WEST SUSSEX COUNTY COUNCIL CONSULTATION

TO:	Arun District Council FAO: Andrew Wood
FROM:	Highways, WSCC
DATE:	0/01/2019
LOCATION:	11, Ocean Drive, Ferring, Worthing, BN12 5QJ
SUBJECT:	FG/219/18/PL Demolition & erection of 1 No. dwelling with associated parking & turning.
DATE OF SITE VISIT:	N/A
RECOMMENDATION:	☒ Advice ☐ Objection ☐ Modification ☐ No Objection ☐ More Information ☐ Refusal
S106 CONTRIBUTION TOTAL:	£N/A

Drw No: 1498/18/P/01A

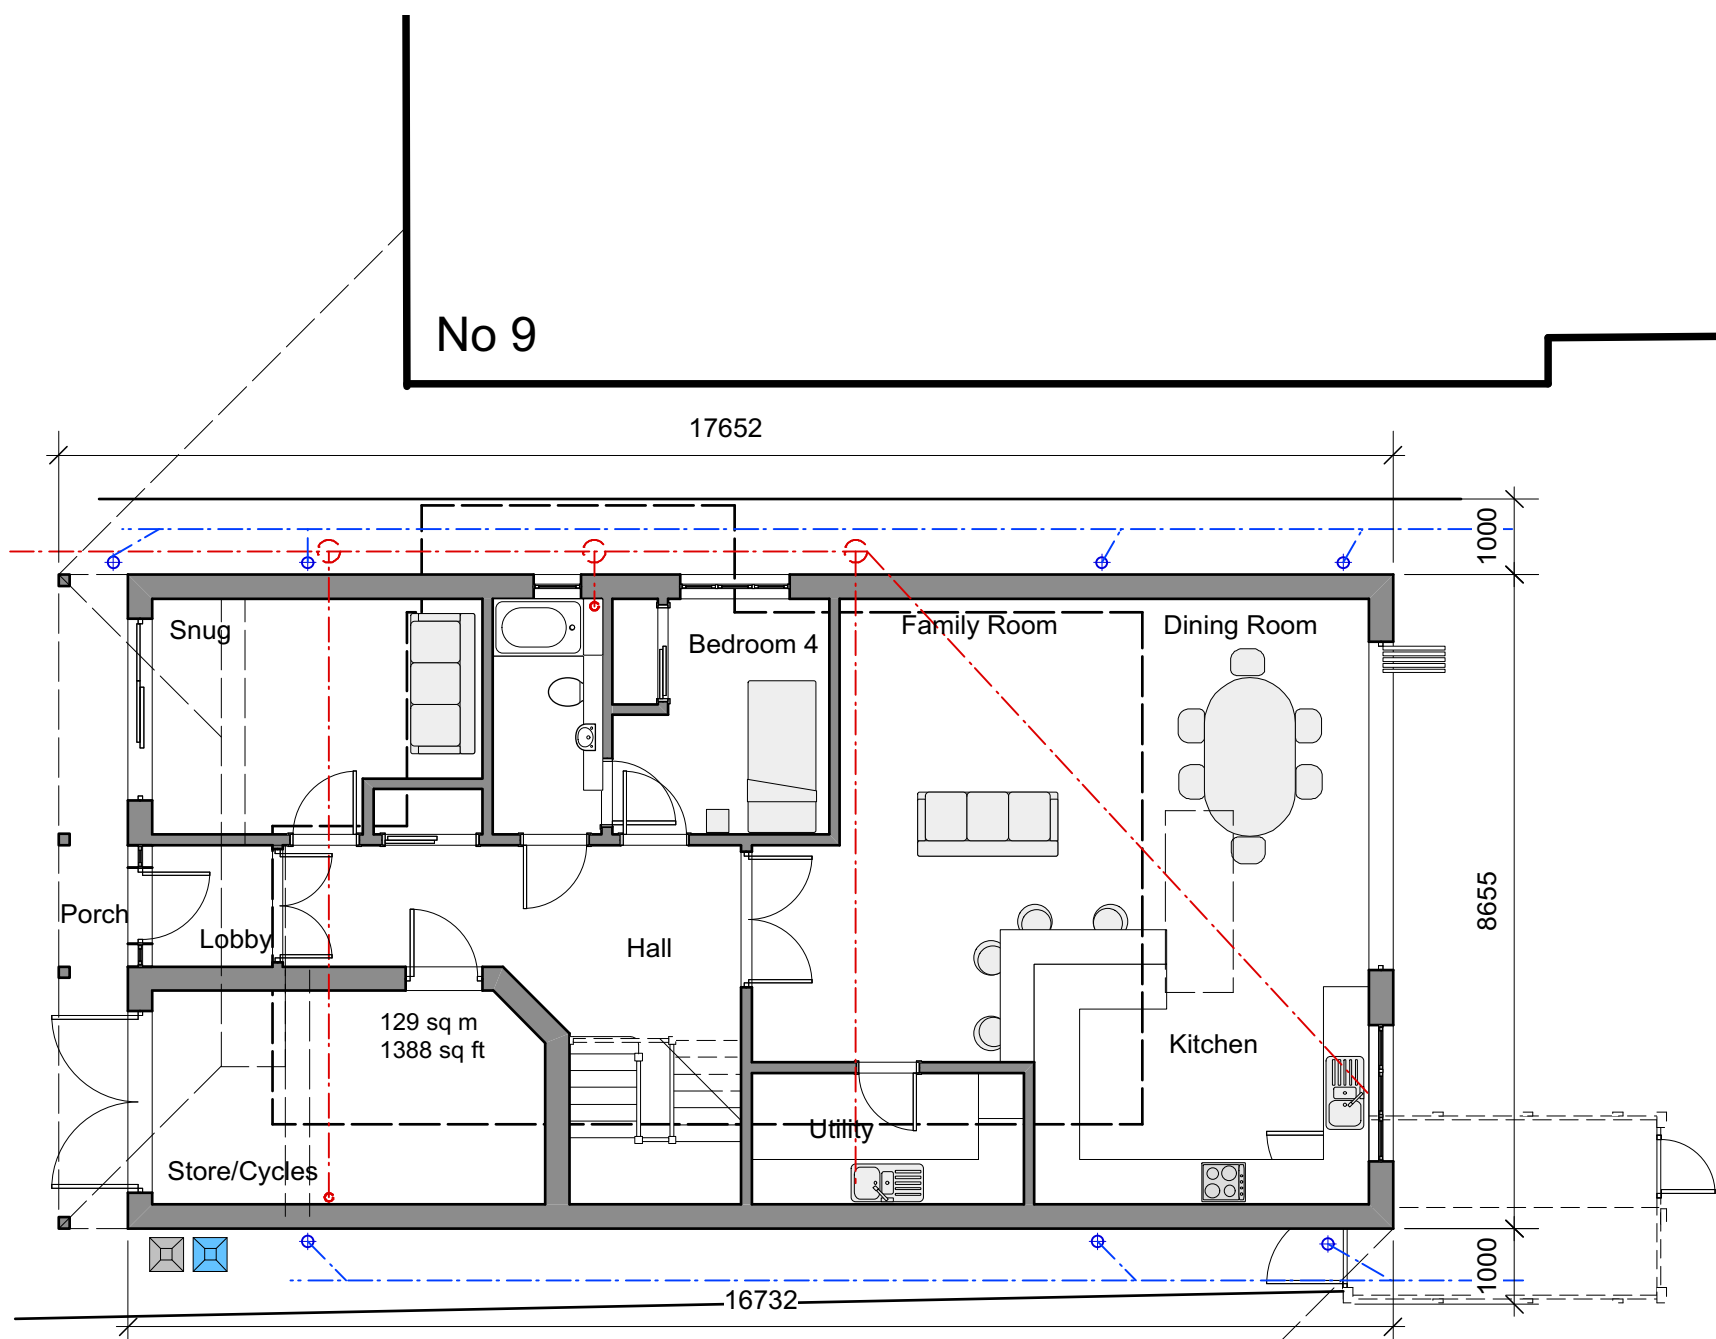
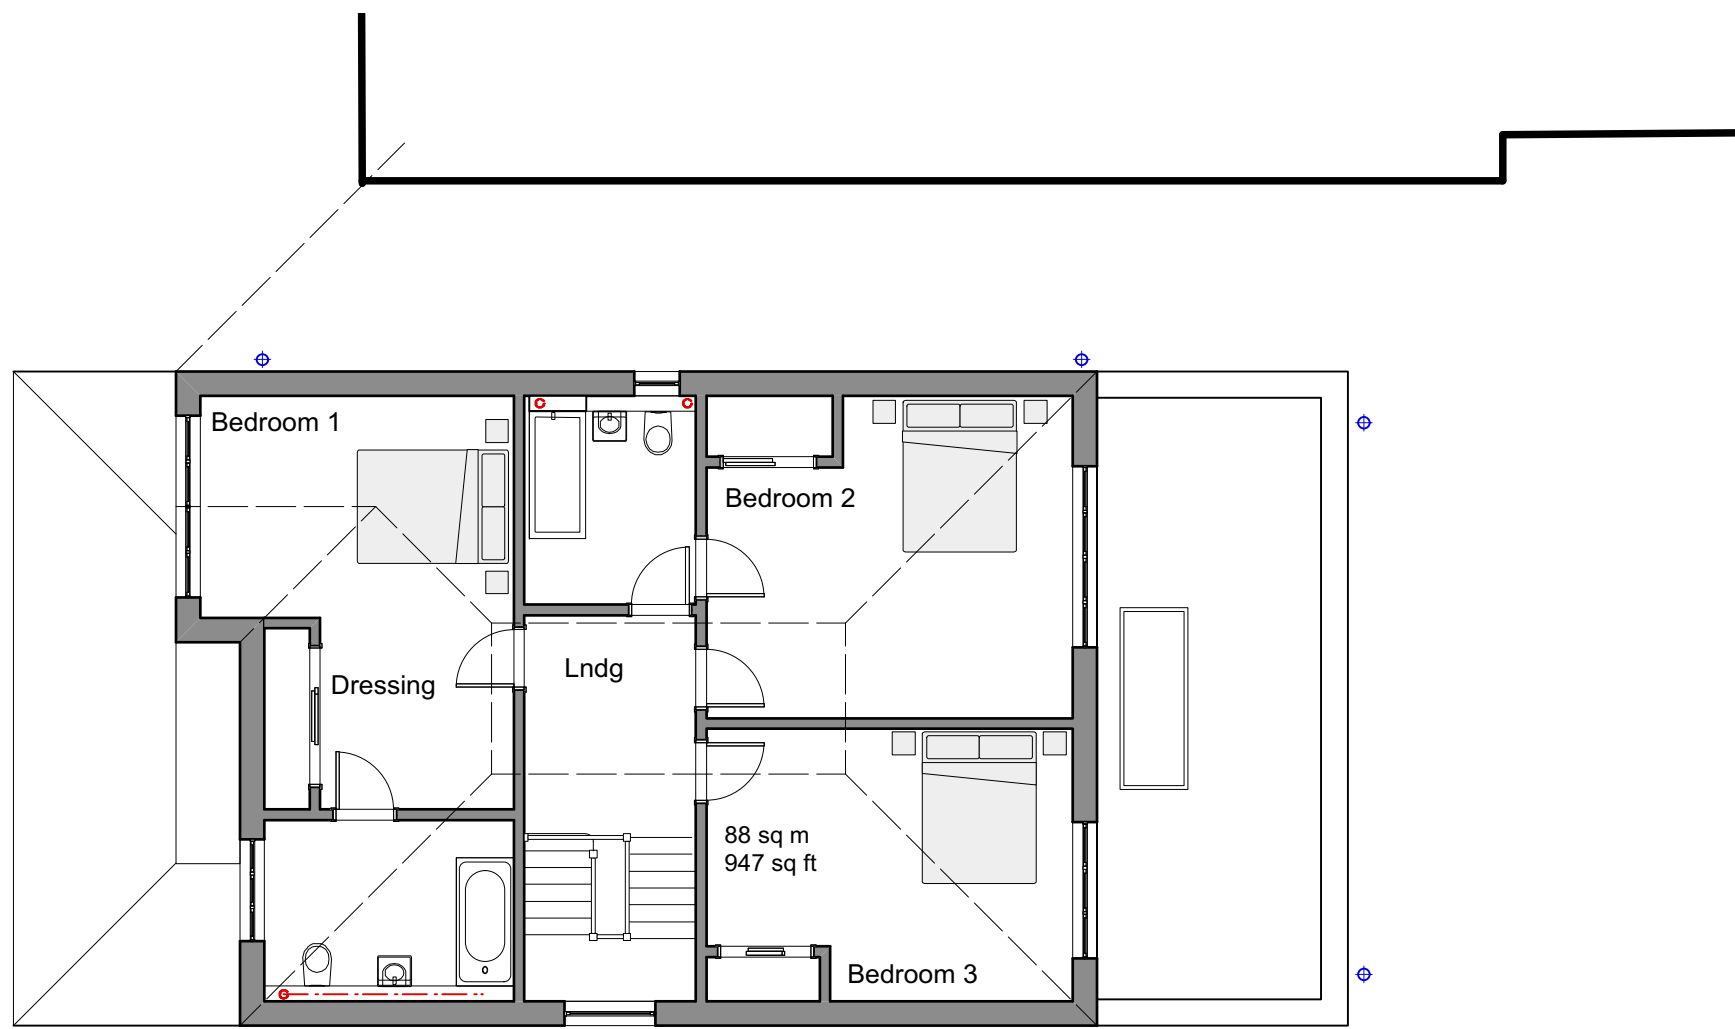
The proposed and existing plans appear to have been labelled incorrectly within the planning portal. The proposed plan titled: 1498/18/P01A indicates that the existing single garage will be demolished and three parking spaces will be provided on the site frontage and a single integral garage will be provided on site. The proposed plans demonstrate internal dimensions of 2.8m x 5.2m. In order to be counted towards parking provision for the dwelling, the minimum internal dimensions should meet

Manual for Streets guidance of 3 x 6m. The applicant is advised to consider increasing the proposed garage depth to meet these minimum internal specifications. However, this is not anticipated to cause a highway safety concern in this location.. This is anticipated to be sufficient parking provision for a dwelling of this size and location. There appears to be sufficient space for vehicles to turn on site and exit in a forward gear.
